A47 Blofield to North Burlingham

Scheme Number: TR010040

Volume 8 **8.13 Statement of Common Ground** **with National Highways** **and Blofield Parish Council**

STATEMENT OF COMMON GROUND

SUITABLE FOR INFORMATION

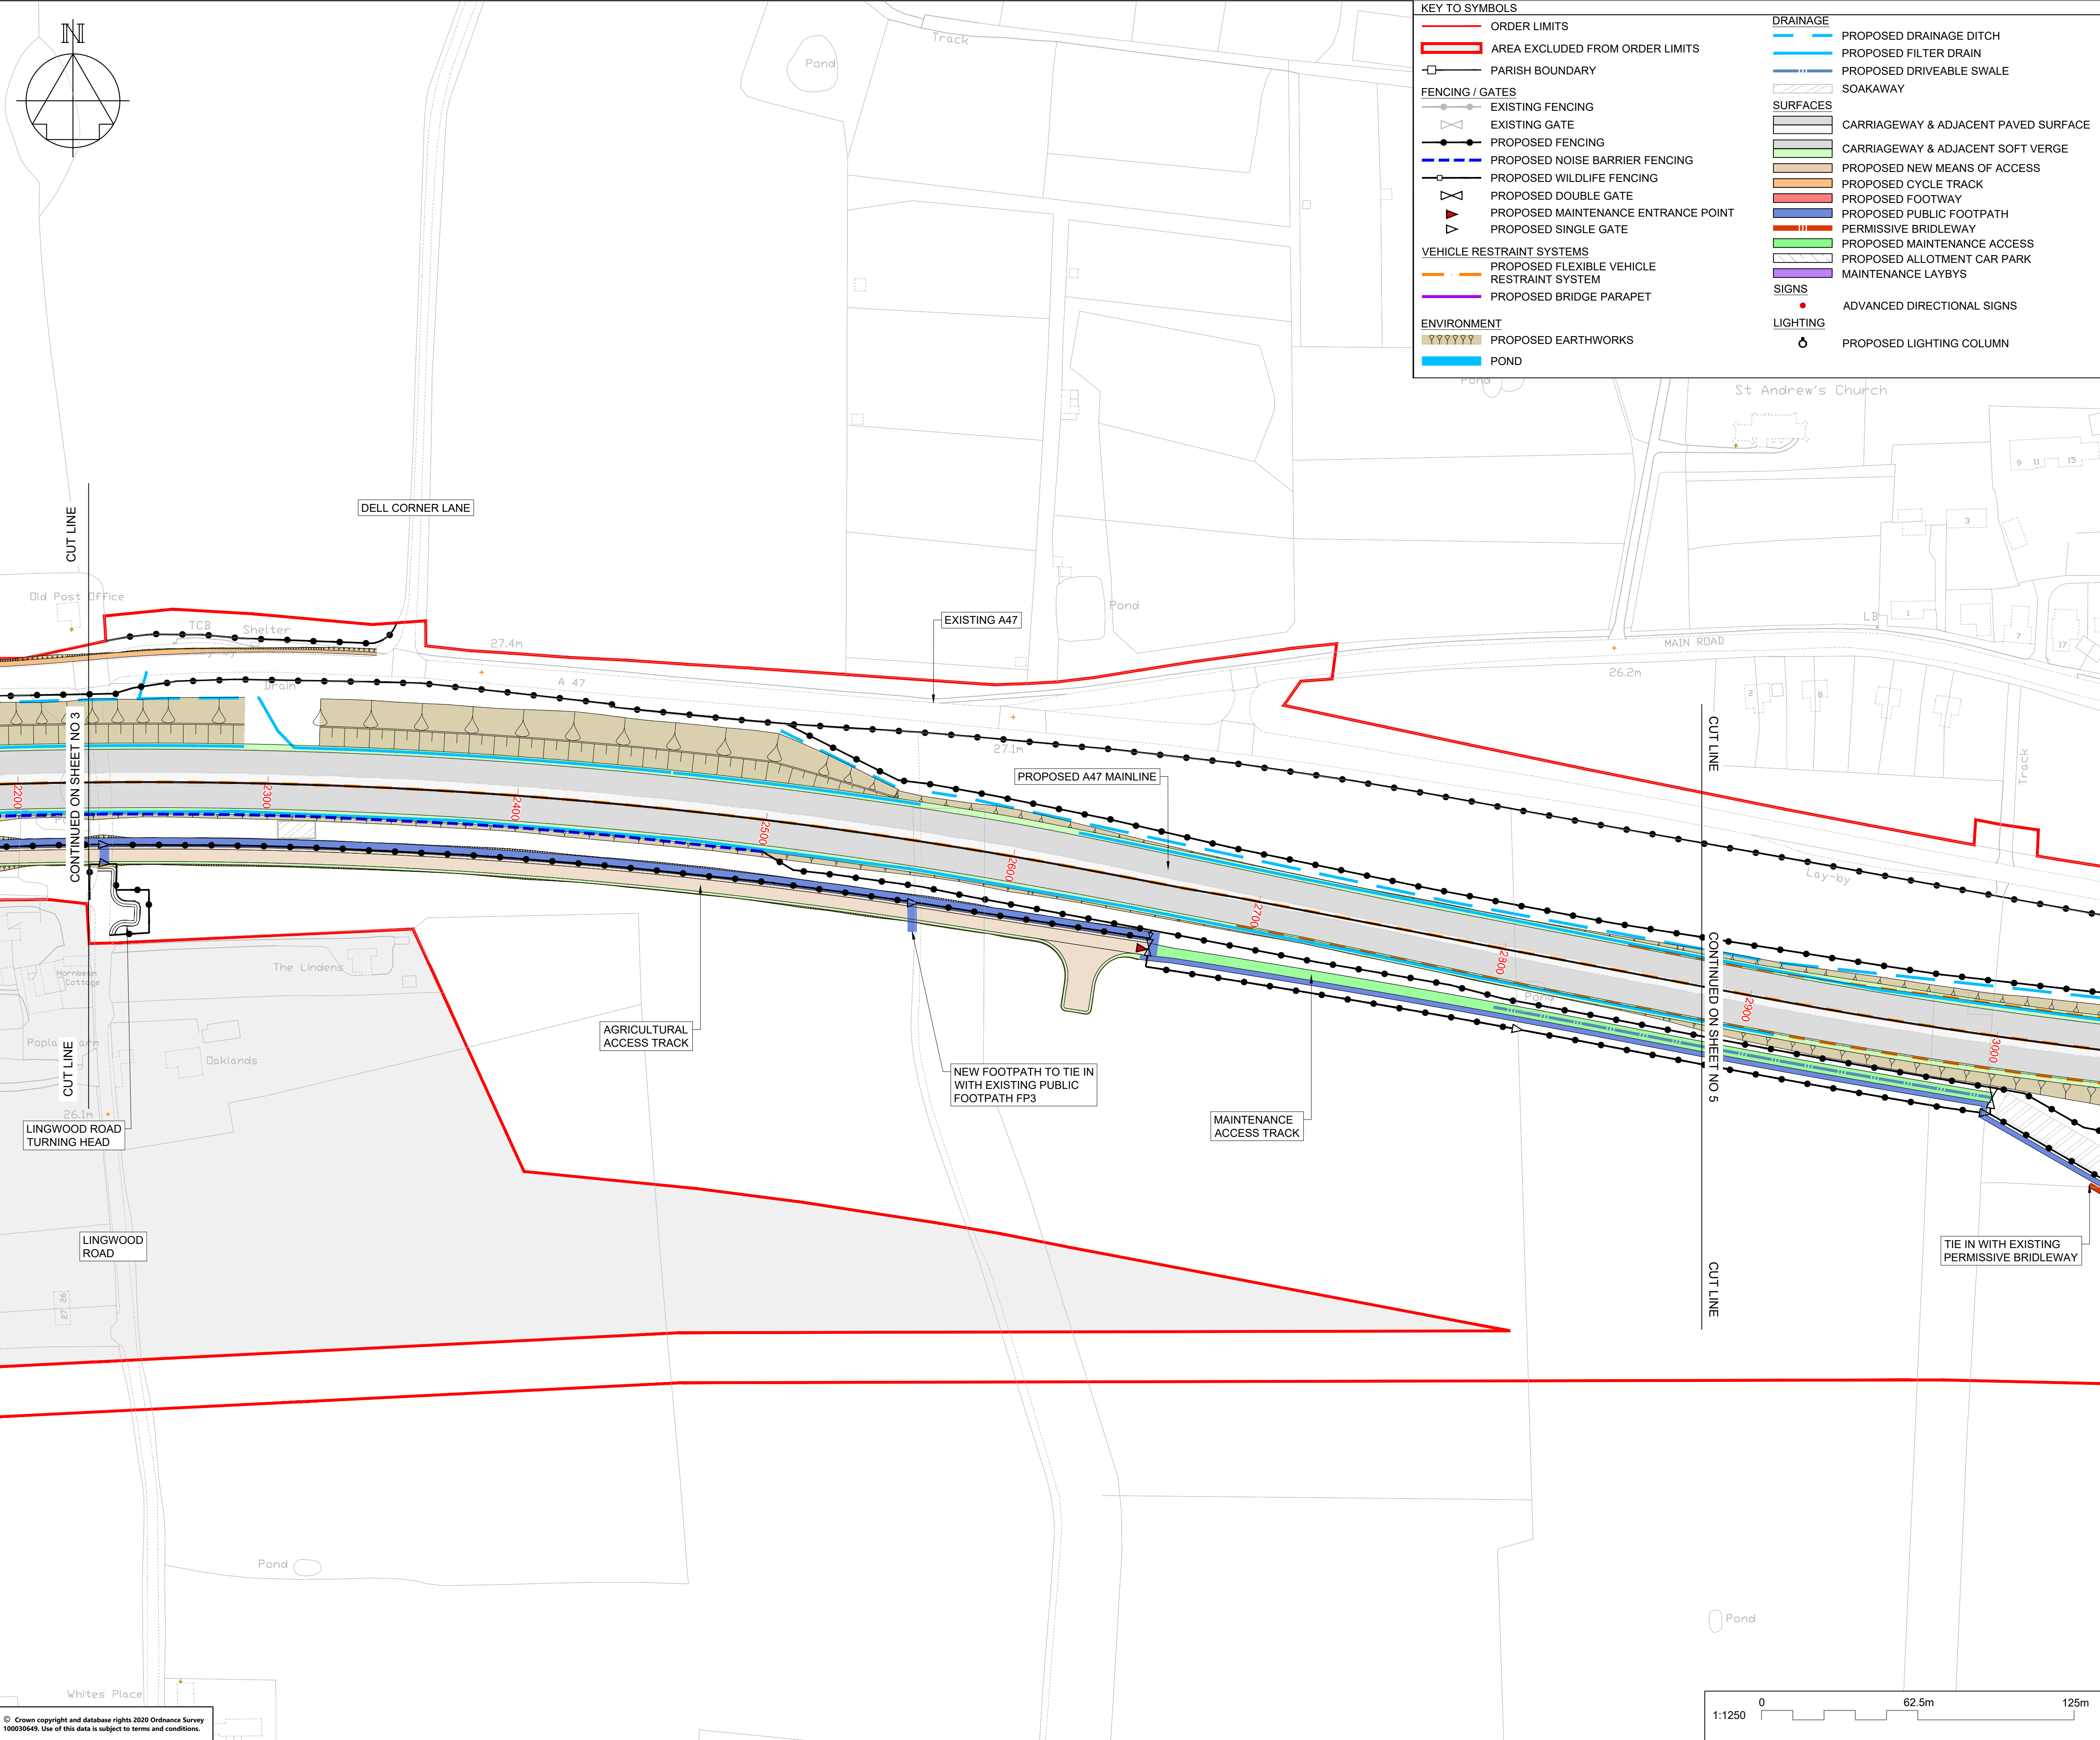
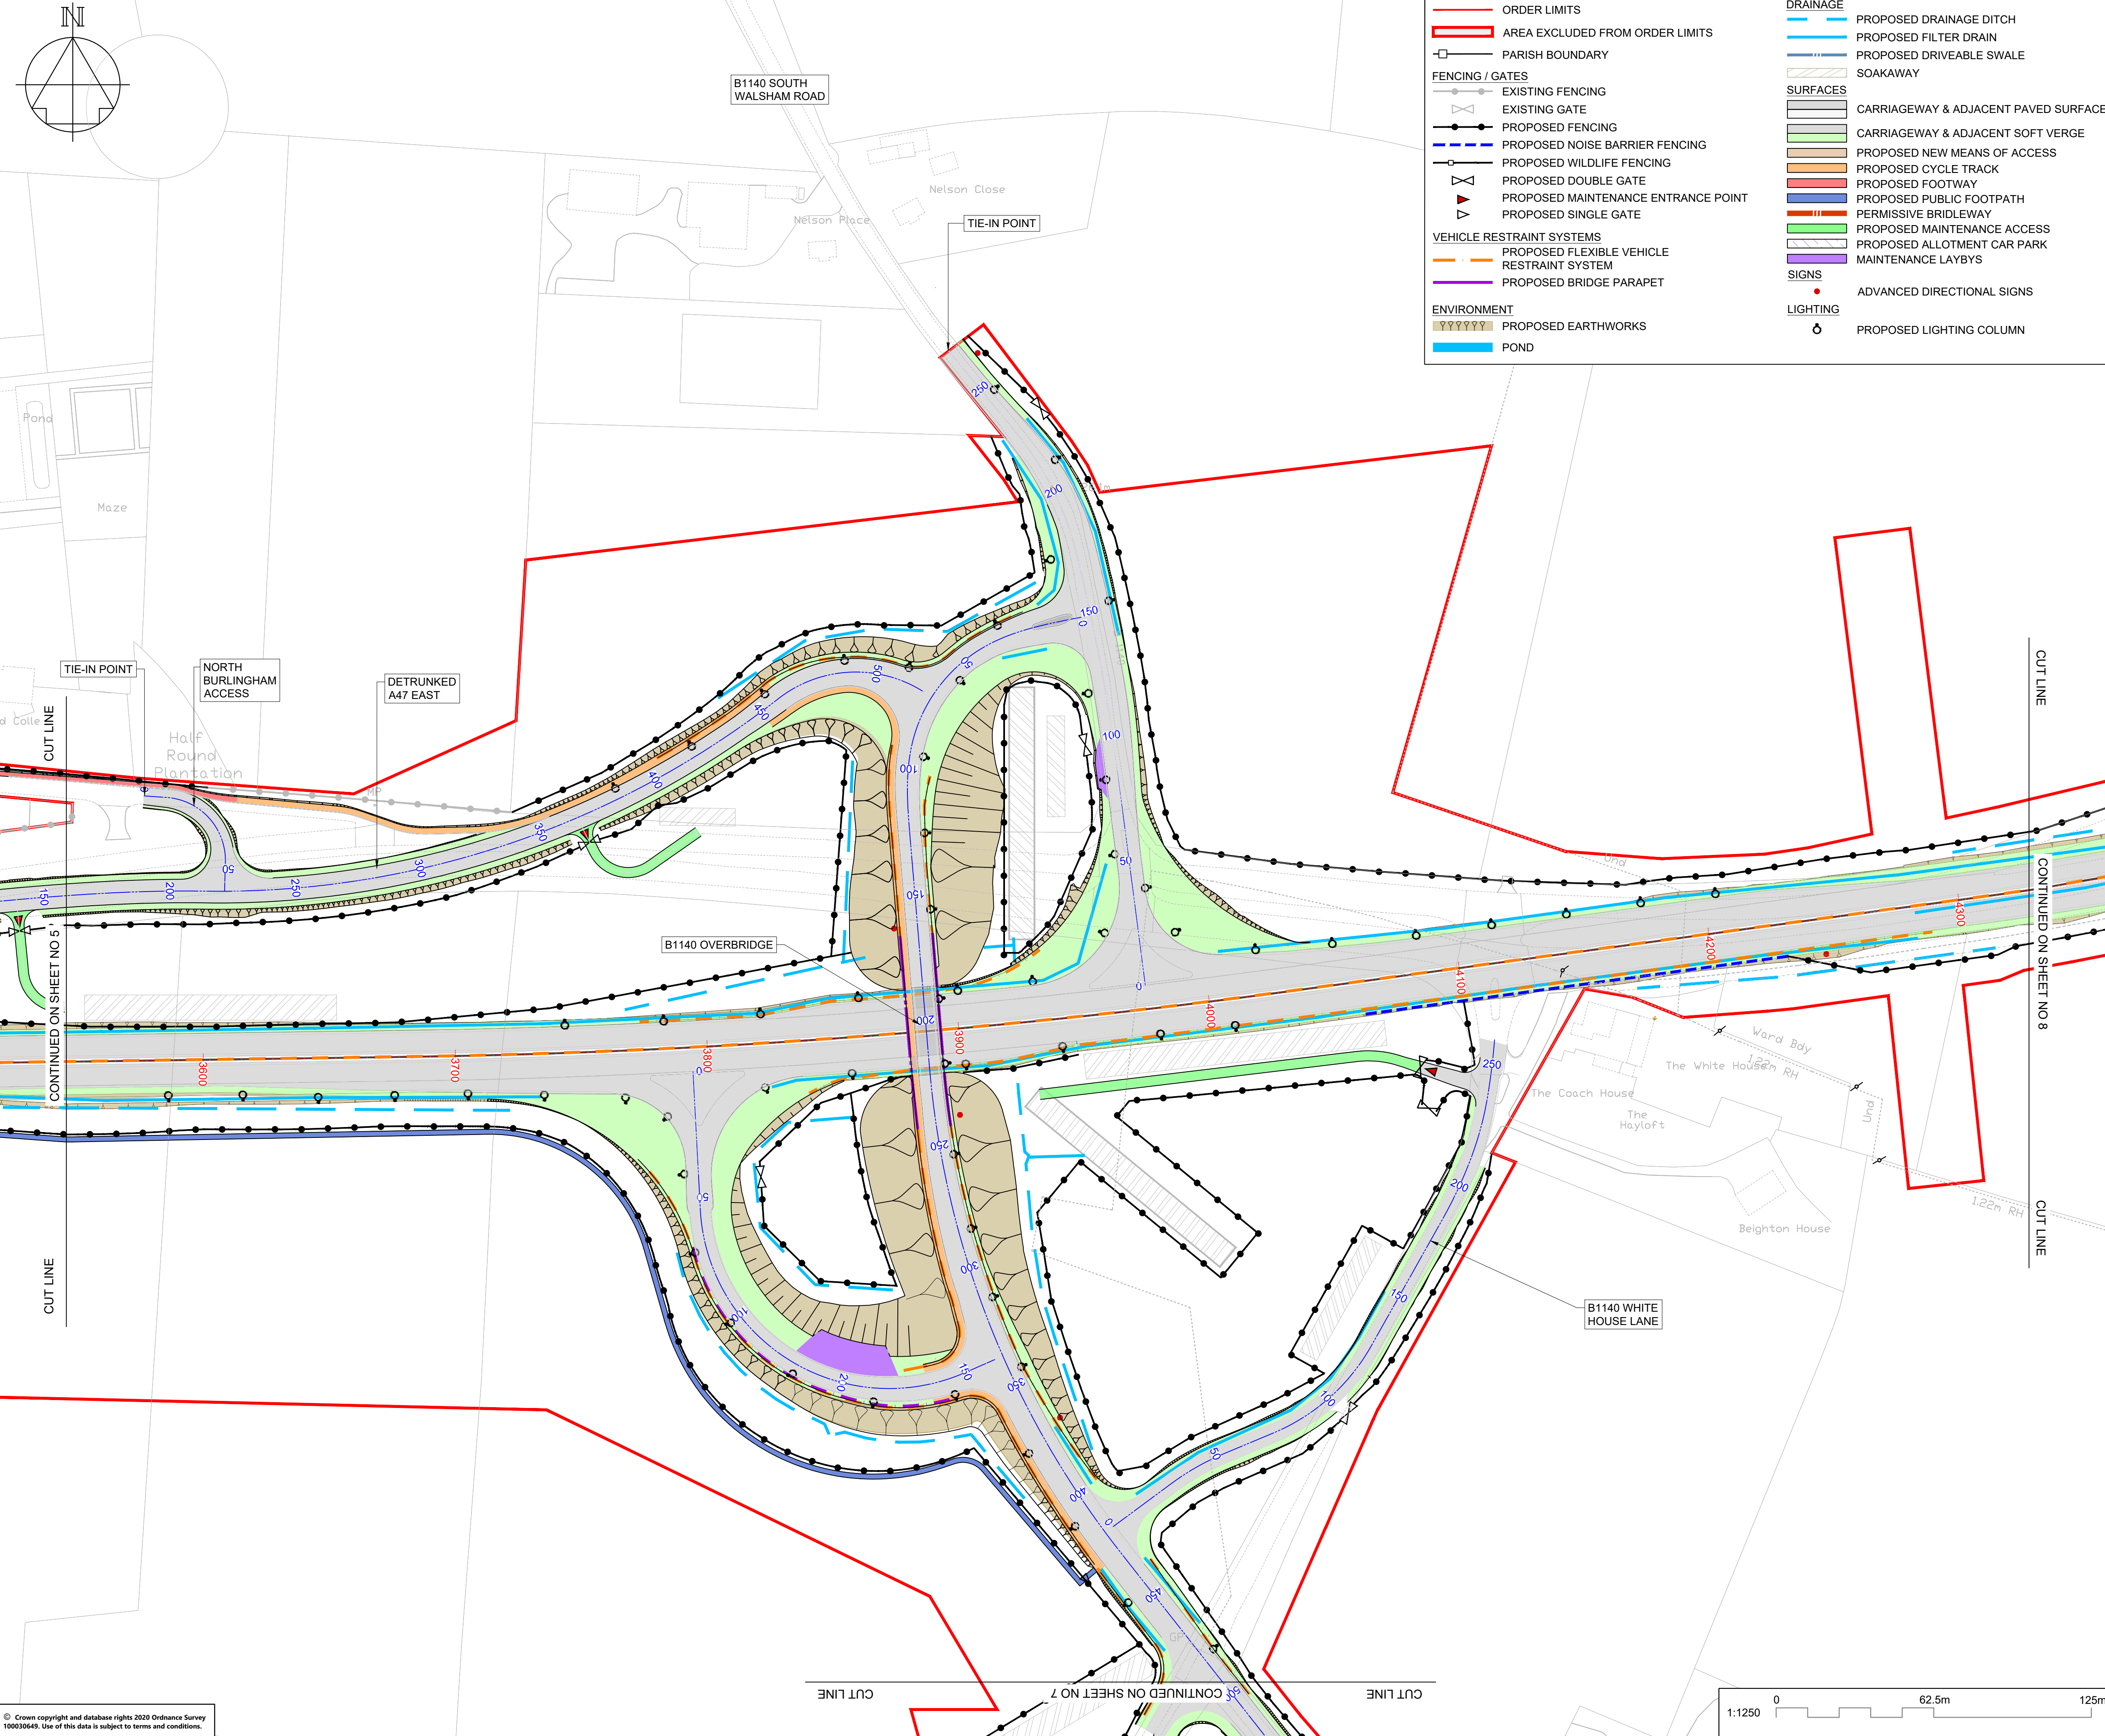
Issue	Document Reference	Blofield Parish Council Comment	Applicant's Response	Status	Date
Blofield Allotments – Water tank	Email from BPC in Appendix F	Unless a new water tank is being provided by HE, the existing one will need to be moved and operational within 48 hours if the move takes place between 1 April and 30 September, when the water supply is turned on and therefore in regular use. Outside these dates there is more flexibility.	See response above in relation to the water tank	Agreed	11-Nov-21
Blofield Allotments – Fencing	Letter from BPC in Appendix A & Letter from BPC in Appendix H	New rabbit proof fencing installed etc. and although these seem minor issues the plot holders are concerned.	The fencing design has been amended to reflect the concerns of the plot holders, as shown on the General Arrangement Plans (REP7-005).	Agreed	11-Nov-21
Blofield Allotments – Fencing	Letter from BPC in Appendix C	Will there be sufficient space to facilitate access to the two haulage ways on the main allotment plots?	The layout of the carpark and fencing has been amended to ensure access to the haulage ways on the main allotment plots, as shown on the General Arrangement Plans (REP7-005).	Agreed	11-Nov-21

Road Lighting	Letter from BPC in Appendix C, Appendix H & Appendix I	<p>2.6 General Arrangement Plans</p> <p>The proposed 20 lighting columns would be in contradiction of the Blofield Neighbourhood Plan Environment 5 Policy regarding Dark Skies. If the proposed junction was amended as per our suggestion at the beginning of this document, then the junction lighting would not be in contradiction to our local plan policy.</p>	<p>As described in the Scheme Design Report (REP1-046) lighting is proposed at the Yarmouth Road as road safety mitigation. The lighting will be LED and include back shields, where appropriate, to limit light spill.</p> <p>The modified junction arrangement as proposed by Blofield Parish Council is not a technically viable solution. Whilst Option B, considered in the Scheme Design Report (REP1-046) may not require lighting, it would have other environmental impacts resulting from the increased land take and additional construction.</p>	Agreed	20-Dec-21
